WELWYN HATFIELD BOROUGH COUNCIL – DEVELOPMENT MANAGEMENT
DELEGATED REPORT

APPLICATION No: S6/2015/1034/MA

SITE ADDRESS: 31 Salisbury Square, Hatfield, AL9 5JD

DESCRIPTION OF DEVELOPMENT: Change of use from existing offices (B1) to six residential dwellings (C3), extension and conversion of existing loft space to one dwelling and erection of new block in existing car park to provide three dwellings

Site & Ground Floor Plan scale 1:100

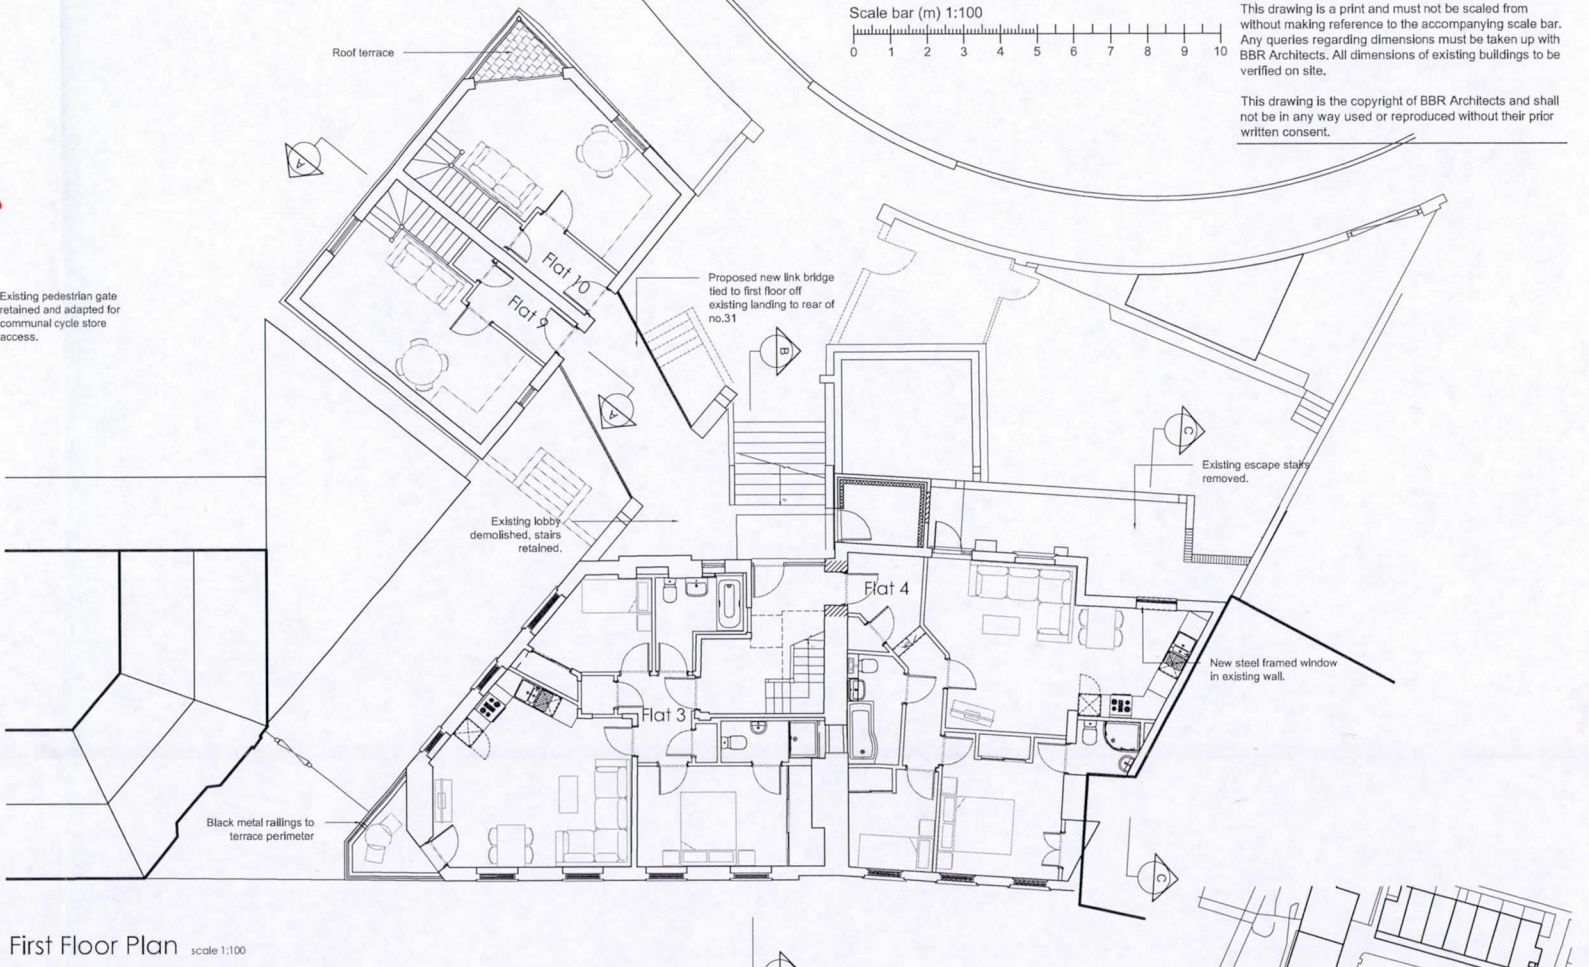
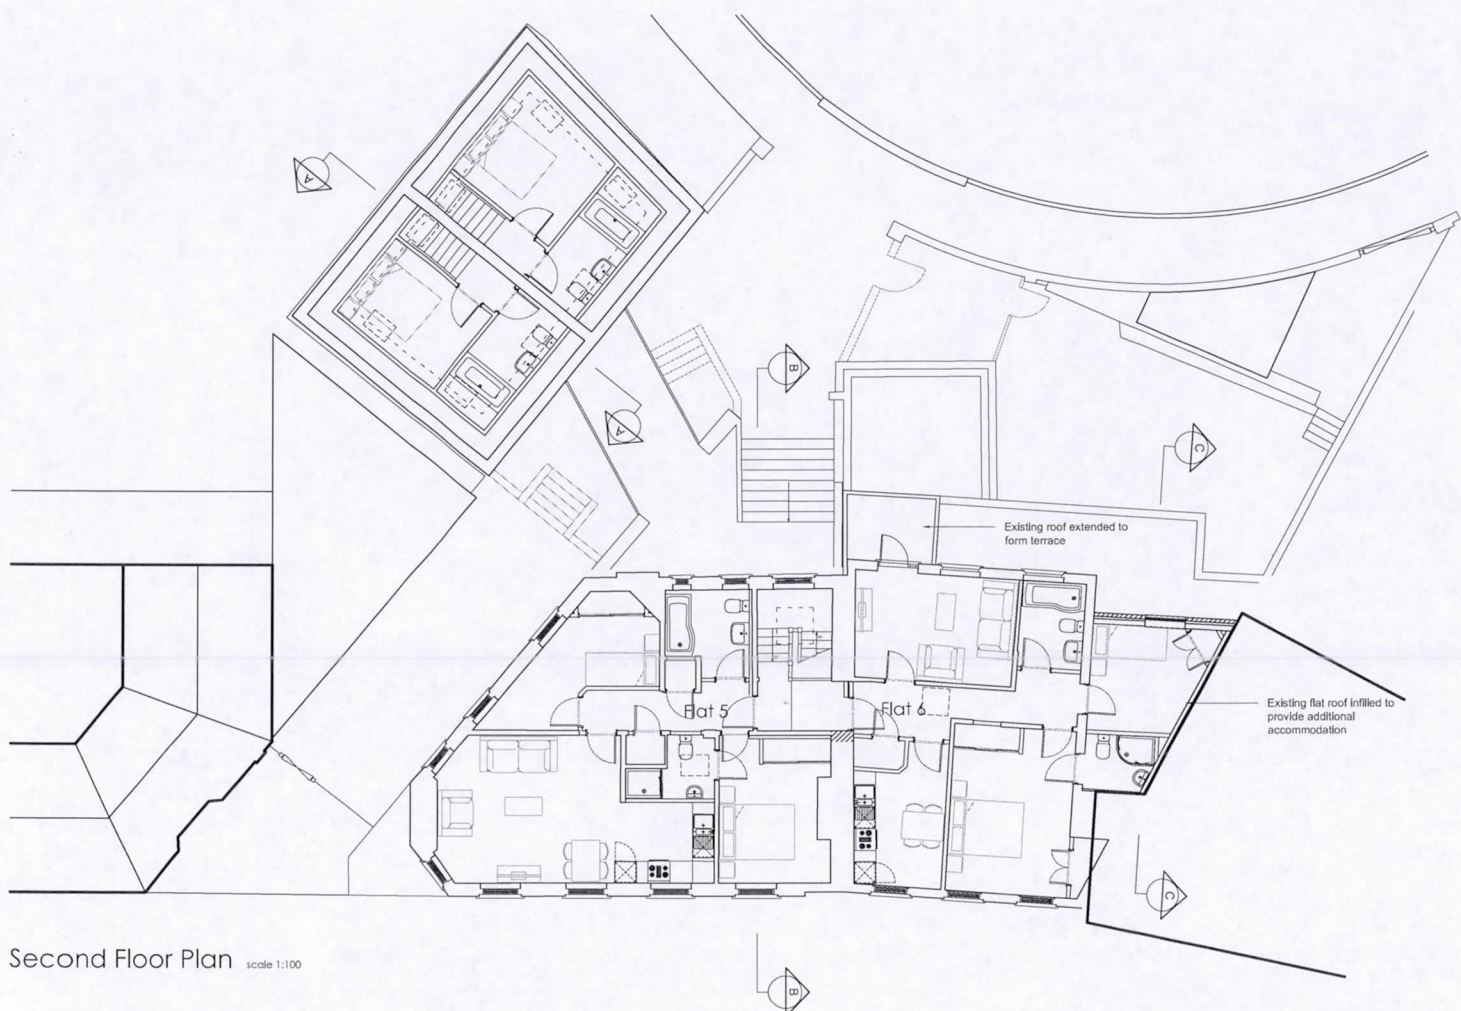
In terms of cycle storage, the Parking Standards SPG identifies a requirement for one long term secure cycle storage space per residential unit. The submitted Site Plan shows that an existing outbuilding would be maintained as a communal cycle store with direct access from Batterdale.

In terms of impact on highway safety, it is proposed to remove the existing crossover to Batterdale and reinstate the footpath as shown on drawing No.P12 Revision A. It is also noted on this drawing that the existing gates are to be adapted to permit pedestrian access only, however, no detail in respect of entry treatment is provided. Without appropriate entry treatment there shall be a potential for vehicles to enter the site, at a point with limited visibility. For this reason details of the pedestrian only gate are sought by condition to ensure a satisfactory standard of development in the interests of highway safety and to ensure the development would be in accordance with the National Planning Policy Framework.

7. Prior to first occupation of the development details of the pedestrian only gate must be submitted to and approved in writing by the Local Planning Authority. Subsequently the development shall not be carried out other than in accordance with the approved details.
